Application No: BN/43/26/DOC
Site Address: Eastmere Stables Eastergate Lane Eastergate PO20 3SJ
Description of works: Approval of details reserved by condition under BN/99/22/OUT (Appeal Ref: APP/C3810/W/22/3312864) relating to condition 9- Surface Water Drainage.

Thank you for your internet representation made on 10th April 2026 which has been recorded as no objection with the comments as follows:

Drawing title  
PROPOSED DRAINAGE PLAN

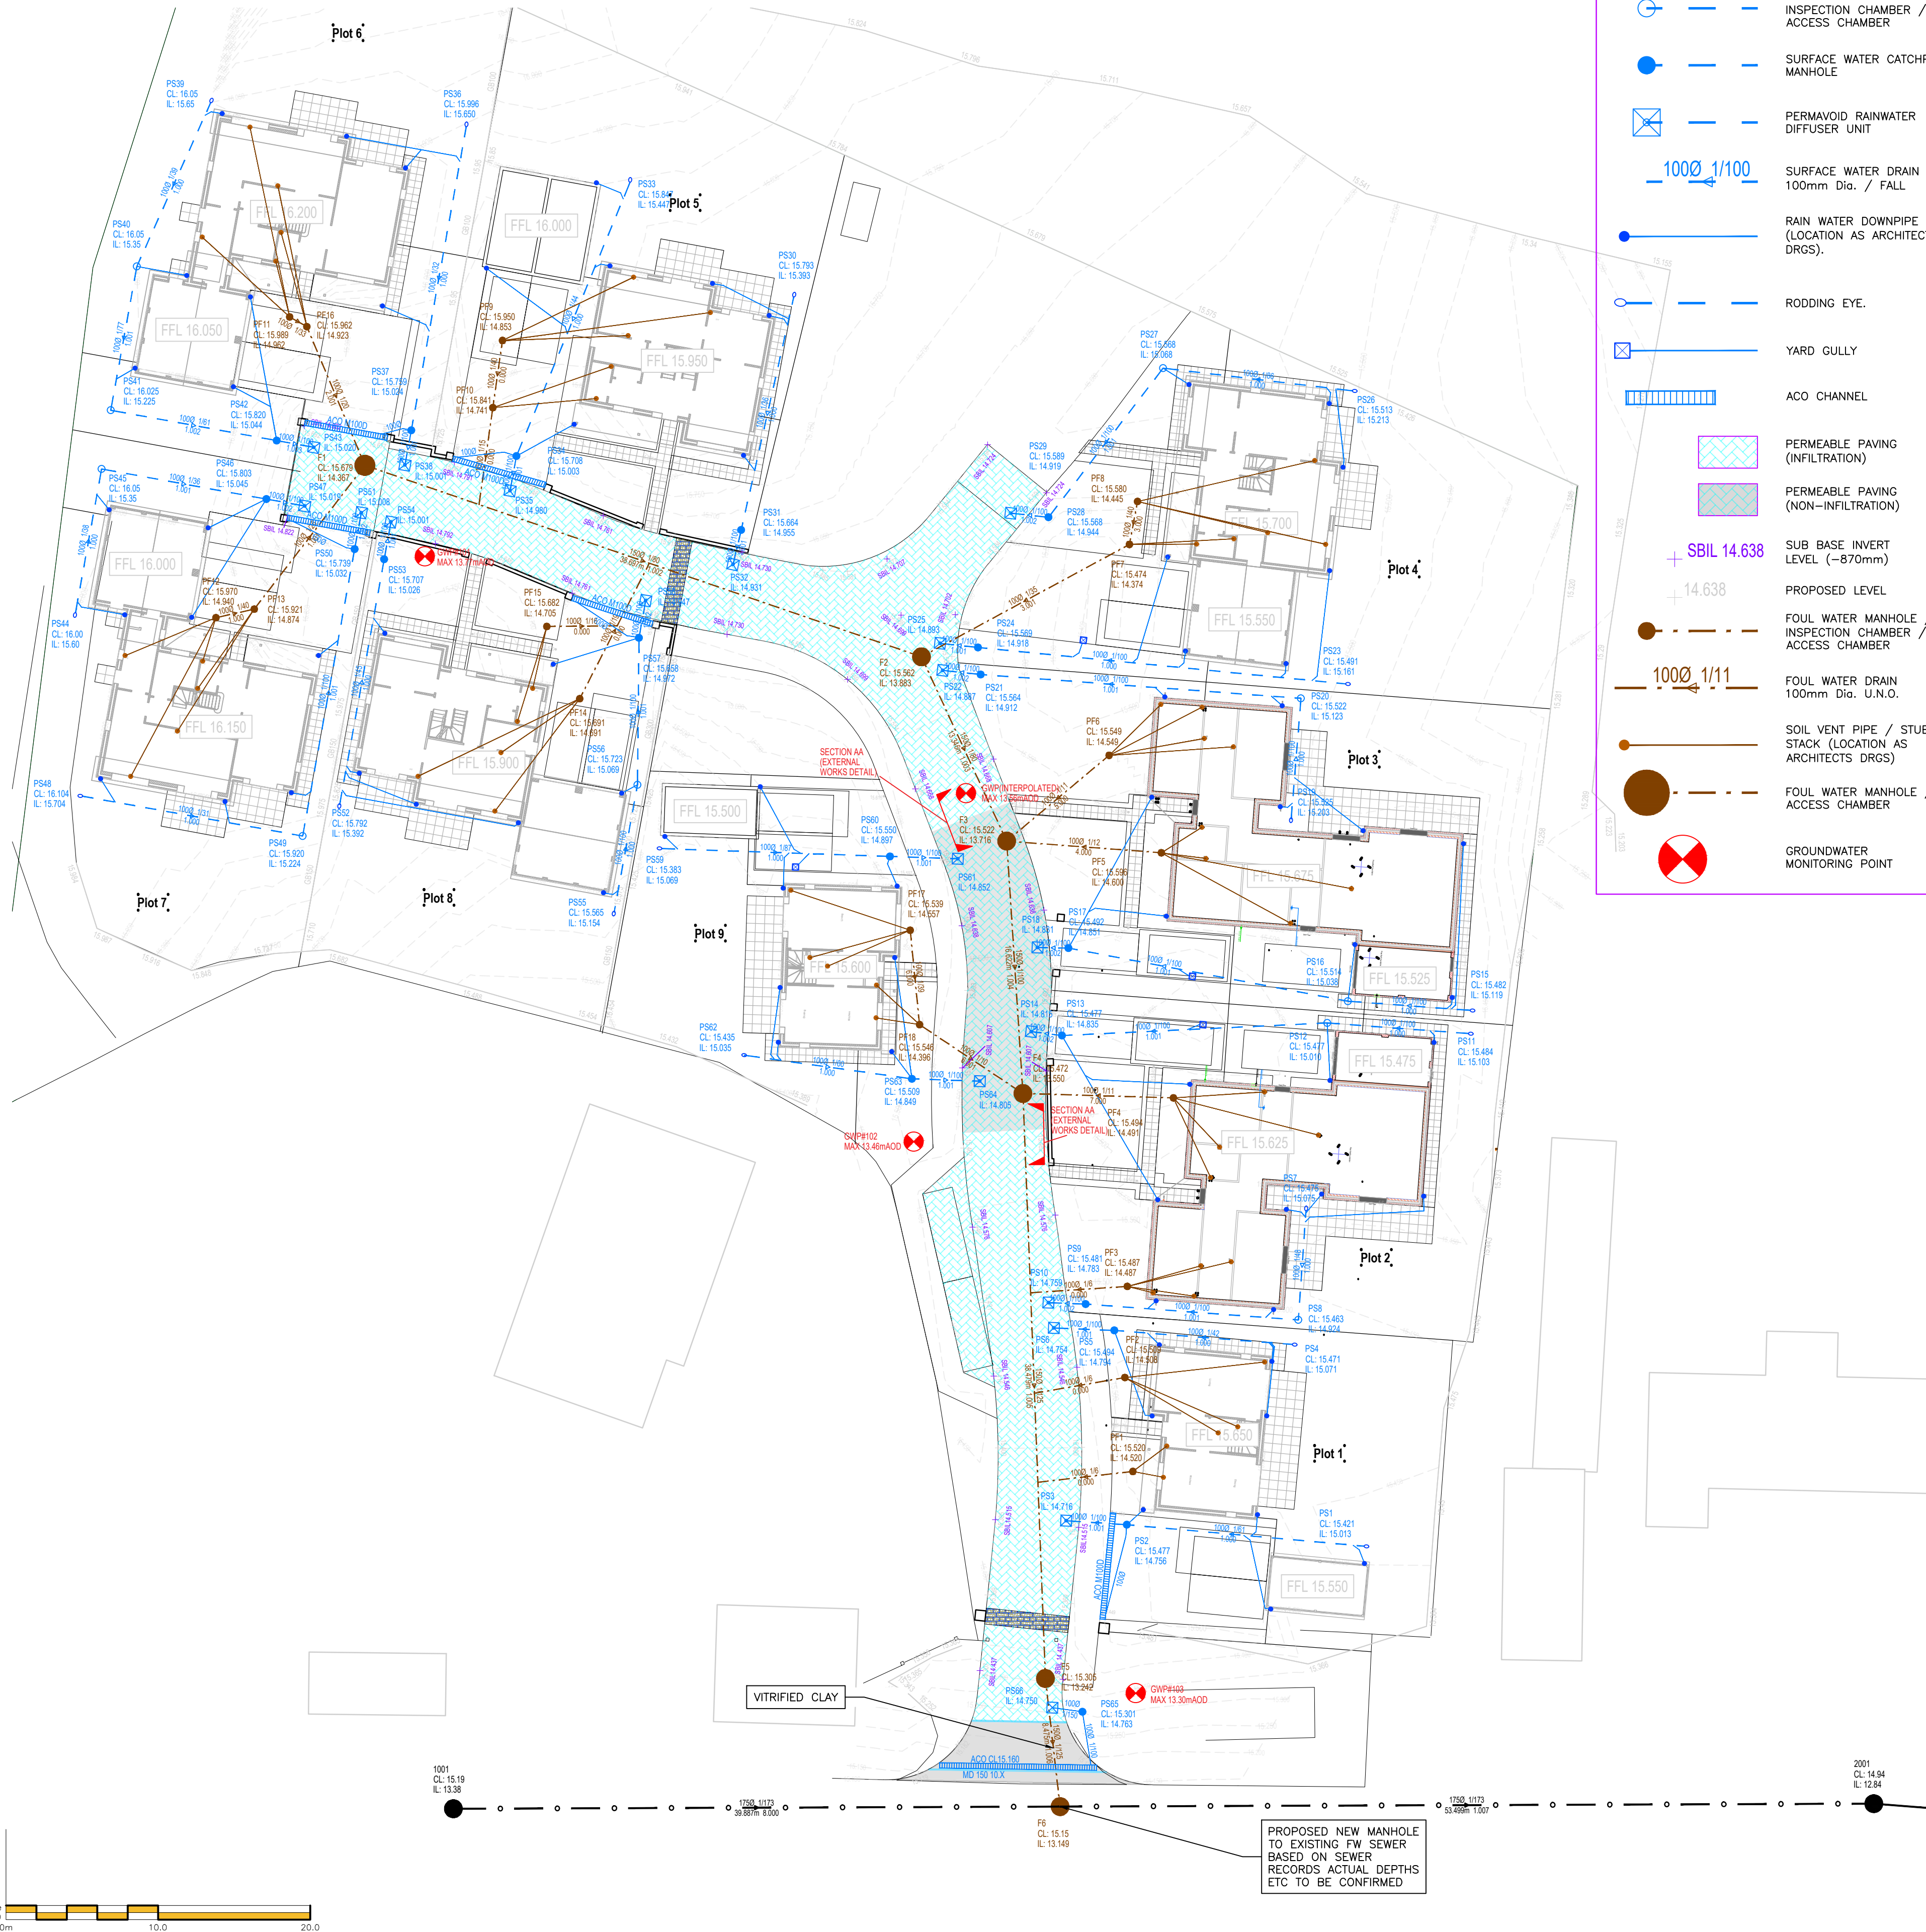
Reading the comment log from the original application for discharge of this condition it appeared that the plan was focusing solely on protection of the houses and that discharge of surface water to the highway was deemed acceptable.

This section of Eastergate Lane already floods and adding to that problem with surface discrete from this site would simply make the existing problem worse.

Should the site's surface drainage plan not have the objective to avoid discharge to the highway?
